Consultation Response from KC Highways

2019/90502 Land off, Fernside Avenue, Almondbury, Huddersfield, HD5 8PH

Erection of 10 dwellings

Date Responded: 22/03/19 Responding Officer: JT Responding Ref: K11-7SW/22

SCALE: 1:250 @A3
 DATE: FEB 2019
 DRAWING NO: 1901502

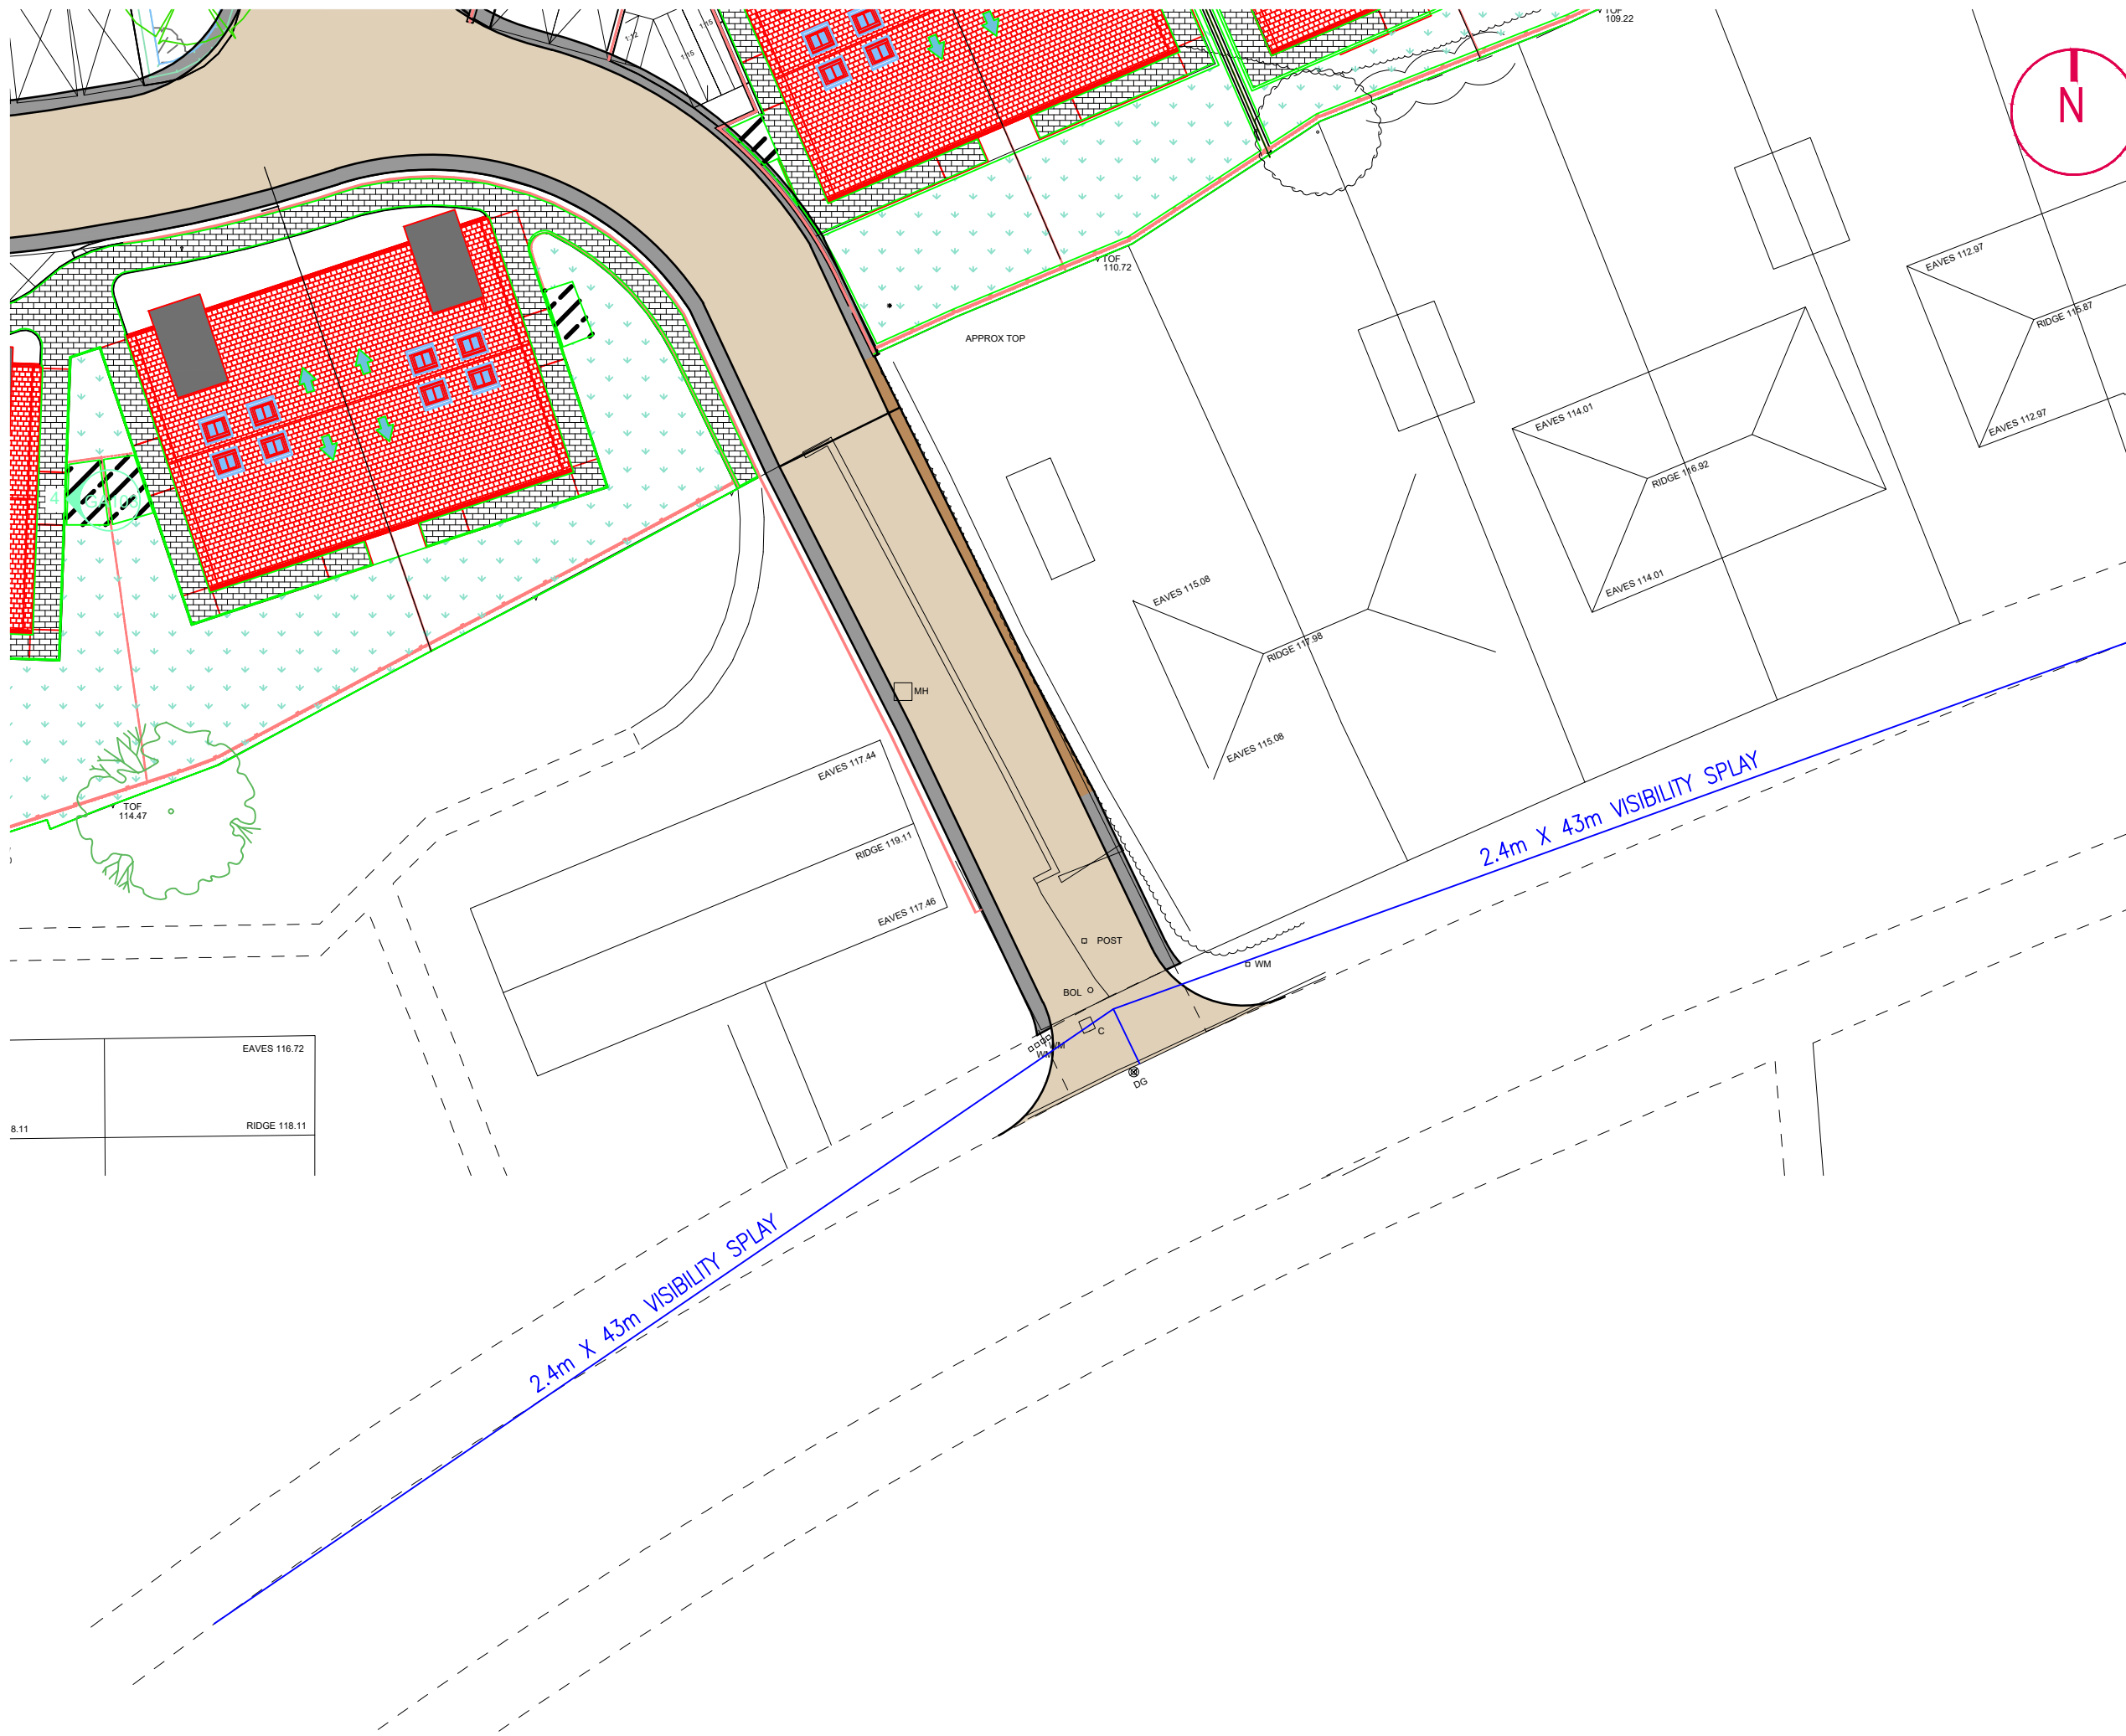
Although there appears to be around 7.2m of width available to create a new access, no detailed design has been provided by the applicant. Visibility splays have also not been demonstrated, but should easily meet the requirements for a 30mph road given the footway is 2.8m wide at this point.

Given the constraints of the access width and size of the site, it is likely a shared surface junction will be the only available option, with a ramp at the point of access to the public highway, 4m radii provided, and a minimum carriageway width of 5m.

- Details of bin collection points demonstrated on a plan, plus storage for each dwelling within 30m of the collection point(s).
- Swept path analysis of an 11.85m refuse vehicle accessing and exiting the site in a forward gear demonstrated on a plan.
- Detailed design of the proposed access onto Fernside Avenue including dimensions of carriageway widths, junction radii, etc.

KIRKLEES REFUSE VEHICLE 2018	
OVERALL LENGTH	11.850m
OVERALL WIDTH	2.500m
OVERALL BODY HEIGHT	3.749m
MIN BODY GROUND CLEARANCE	0.302m
TRACK WIDTH	2.490m
LOCK TO LOCK TIME	6.00s
WALL TO WALL TURNING RADIUS	11.000m

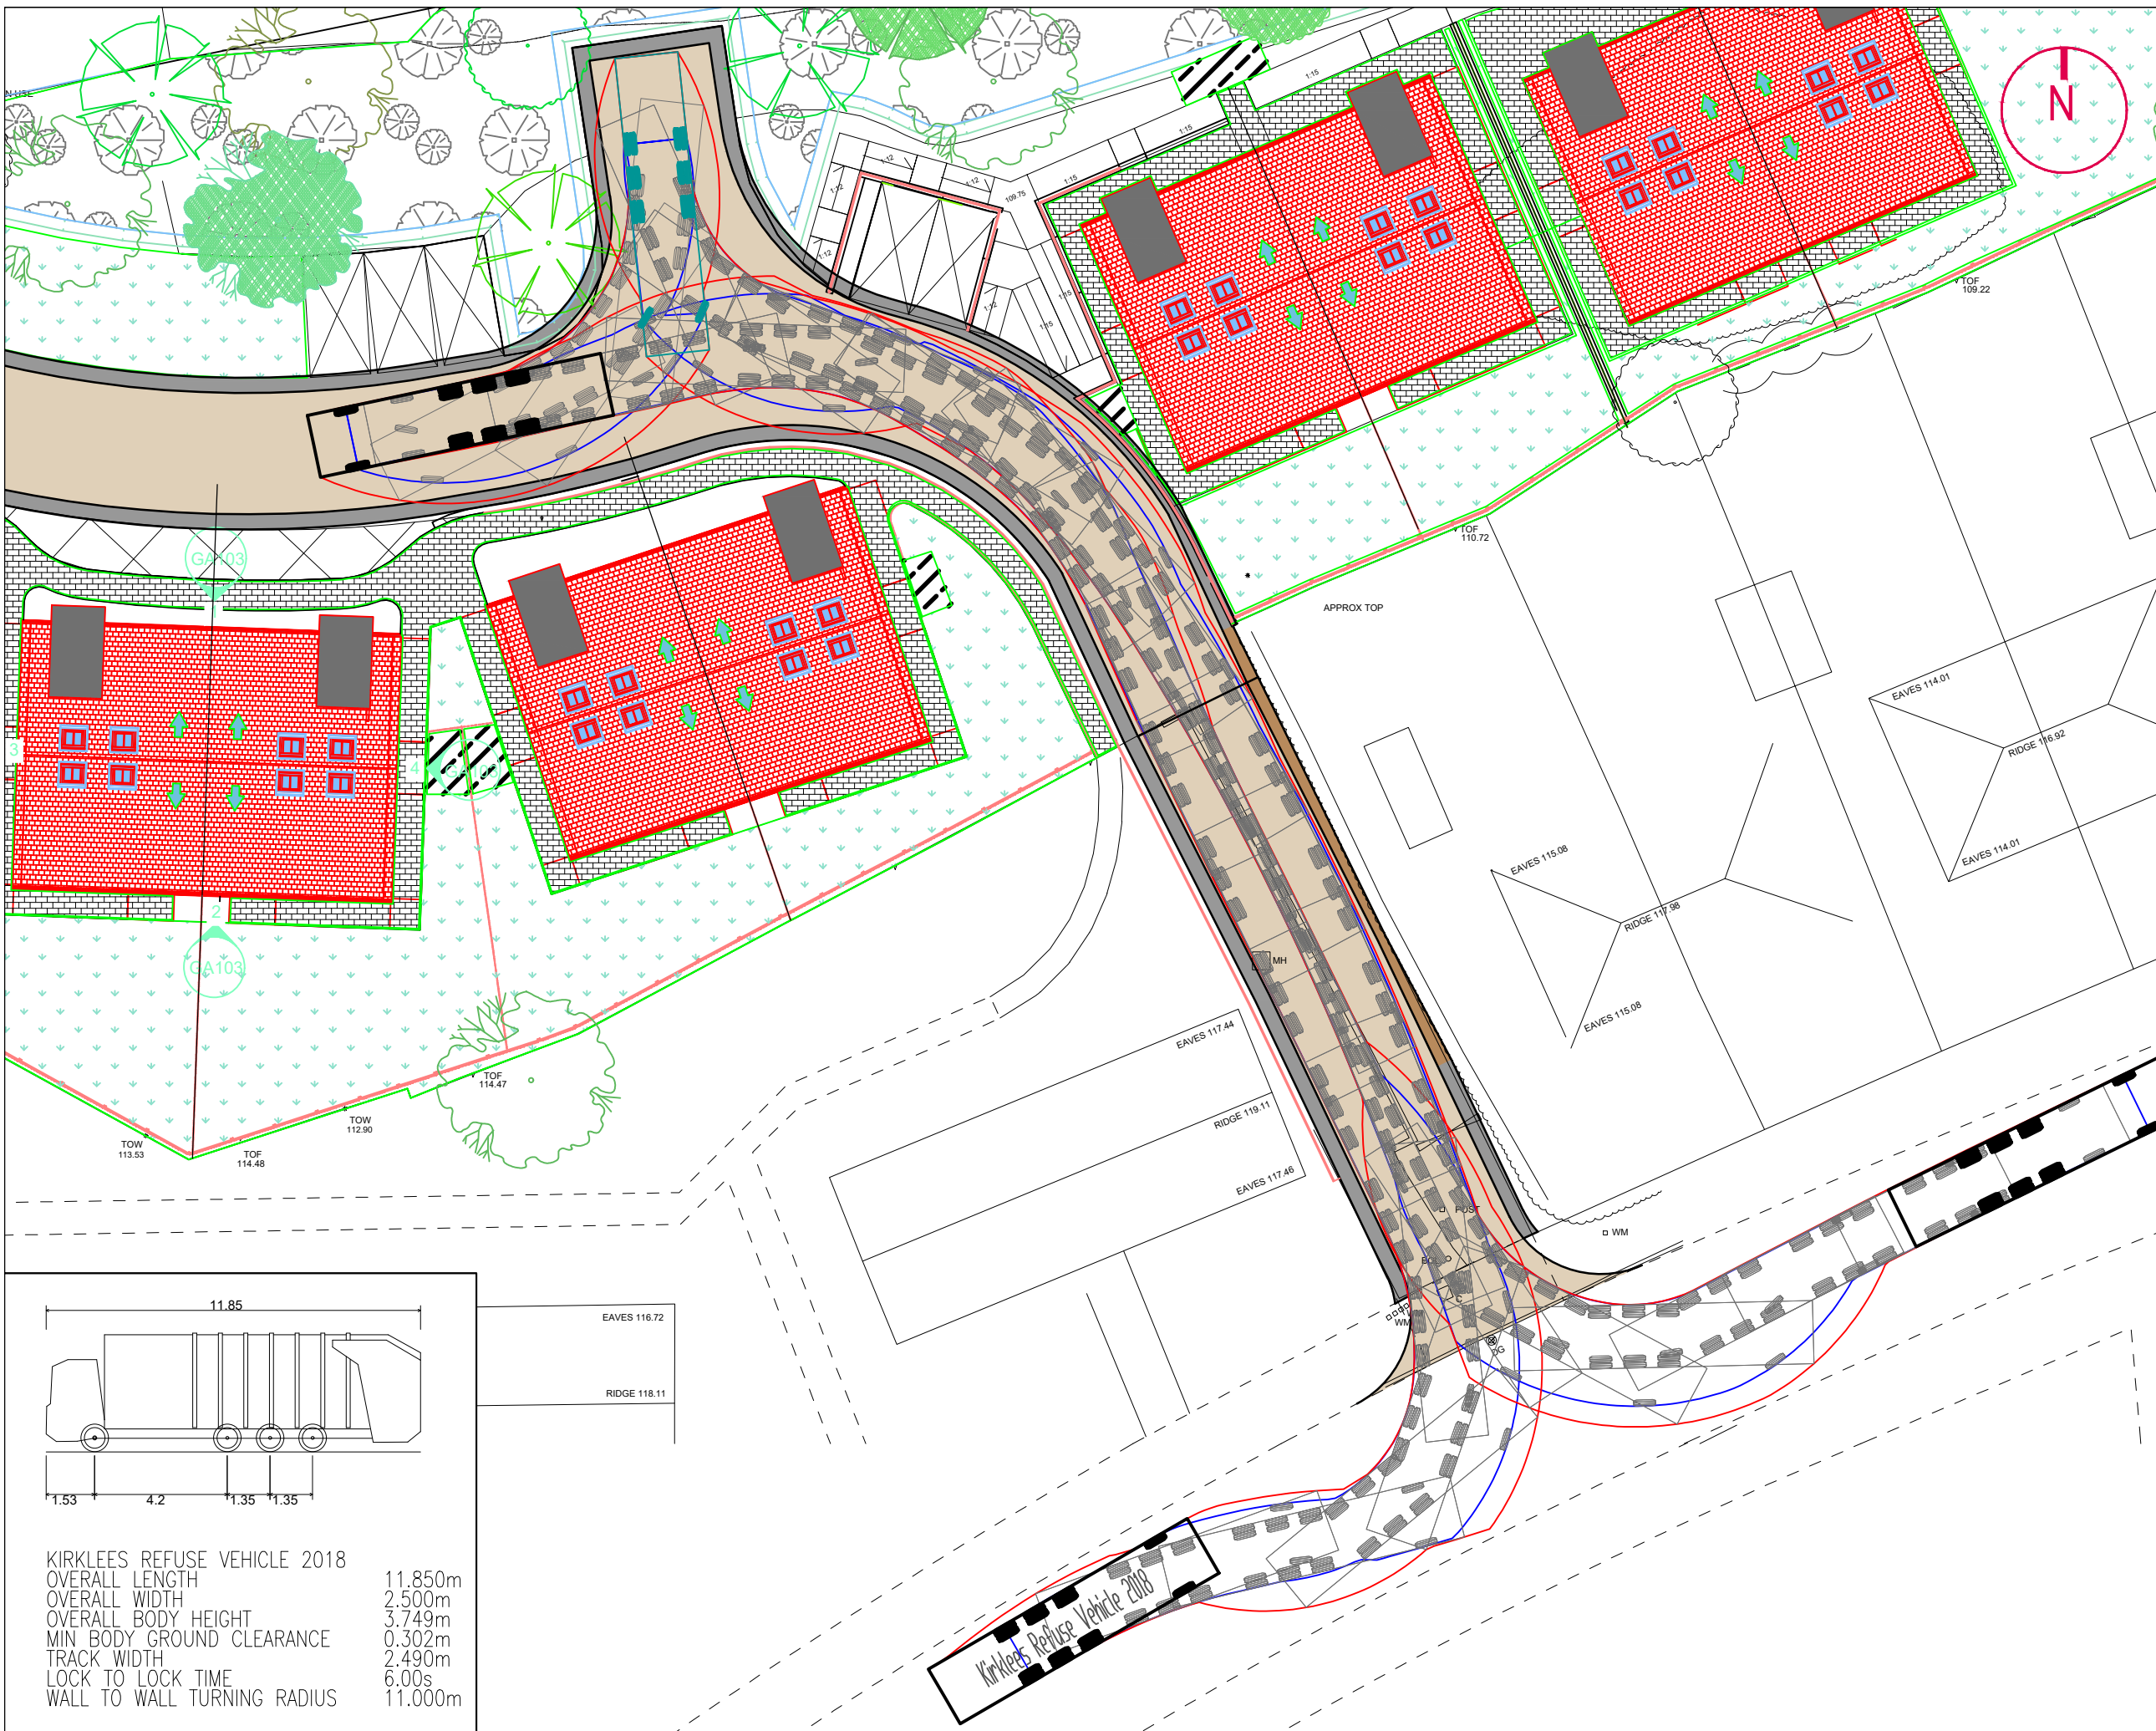
Whilst bin storage is demonstrated, no bin collection points are shown on drawing no. GA101. Some storage points are well beyond the acceptable distances from the collection vehicle. Depending on how this is resolved, some of the dragging distances from storage points may exceed the 30m maximum recommended. The turning facility is welcomed and may aid refuse collection, but swept path analysis would be required showing that an 11.85m refuse wagon can turn within the site. Access and egress by a fire appliance in a forward gear will also be required.
